Current Zoning: O-2 (office) and B-1 (neighborhood business)
Proposed Zoning: NS (neighborhood services)

Approximately 0.45 acres located on the east side of The Plaza, north of Mimosa and south of Mecklenburg Avenue.

The petition proposes to allow all uses in the NS district in an existing building, subject to prohibited uses. The site is located just outside the Plaza-Midwood Historic District.

Revised Site Plan 11.14.22

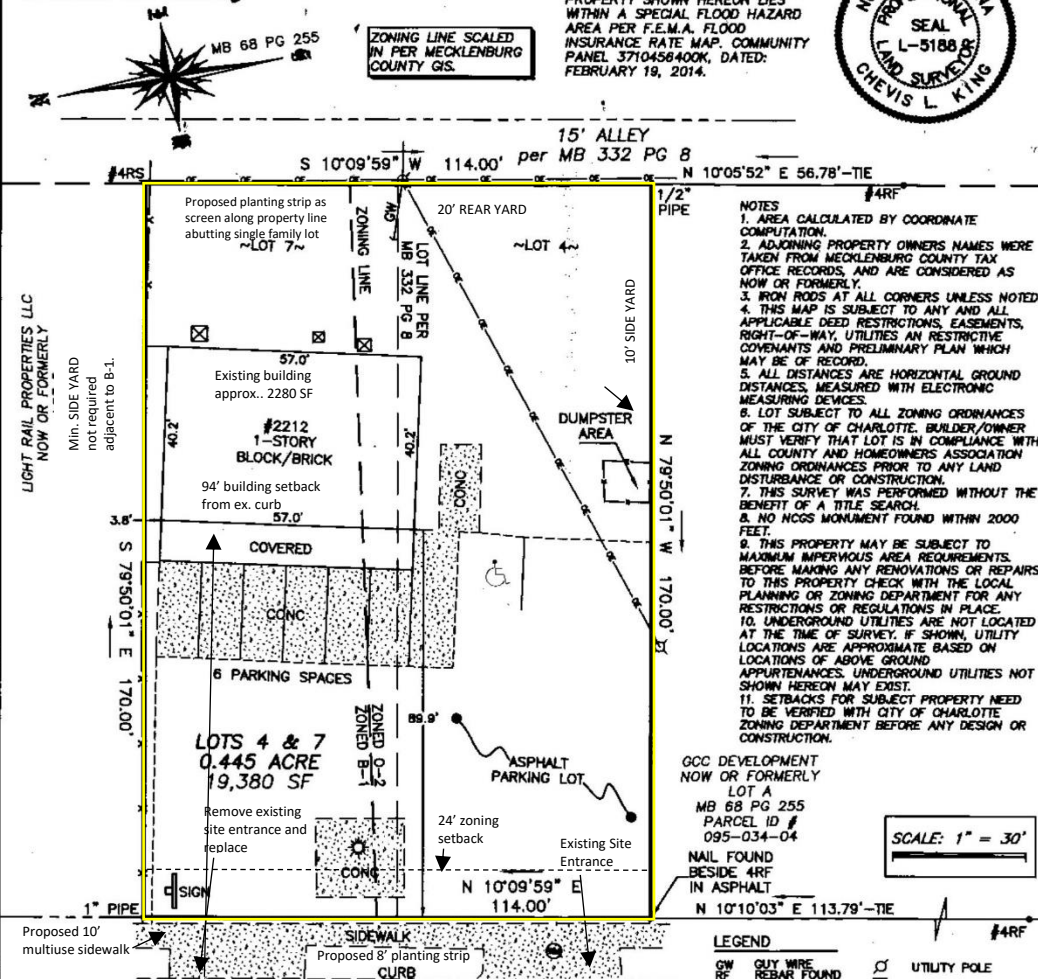
- ~~1. Remove "if needed" and "is needed" at the end of conditional notes shown below:~~ Addressed

- Vehicular access to Site shall be via one of the current driveways as shown on the site plan
- Close northern driveway
- All improvements will be approved and constructed before the site's first building CO is issued **if needed**
- commit to remarking current bike lane pavement markings to a dedicated right turn lane, a bike ramp near south property line per CLDSM 10.43 to transition bicyclists from separated bike lanes to multi-use path and extending the 10-foot multi-use path to the southern property.
- Commit to striping and dedicated right turn arrow per CDOT pavement marking standards
- commit to dedicating 50-feet of right-of-way if it does not currently exist.
- fee simple conveyance of all rights-of-way to the City before the site's first building certificate of occupancy is issued **is needed**

- ~~3. Commit to providing a minimum 10-foot Class C buffer along property lines abutting residential zoning and/or use.~~ Addressed
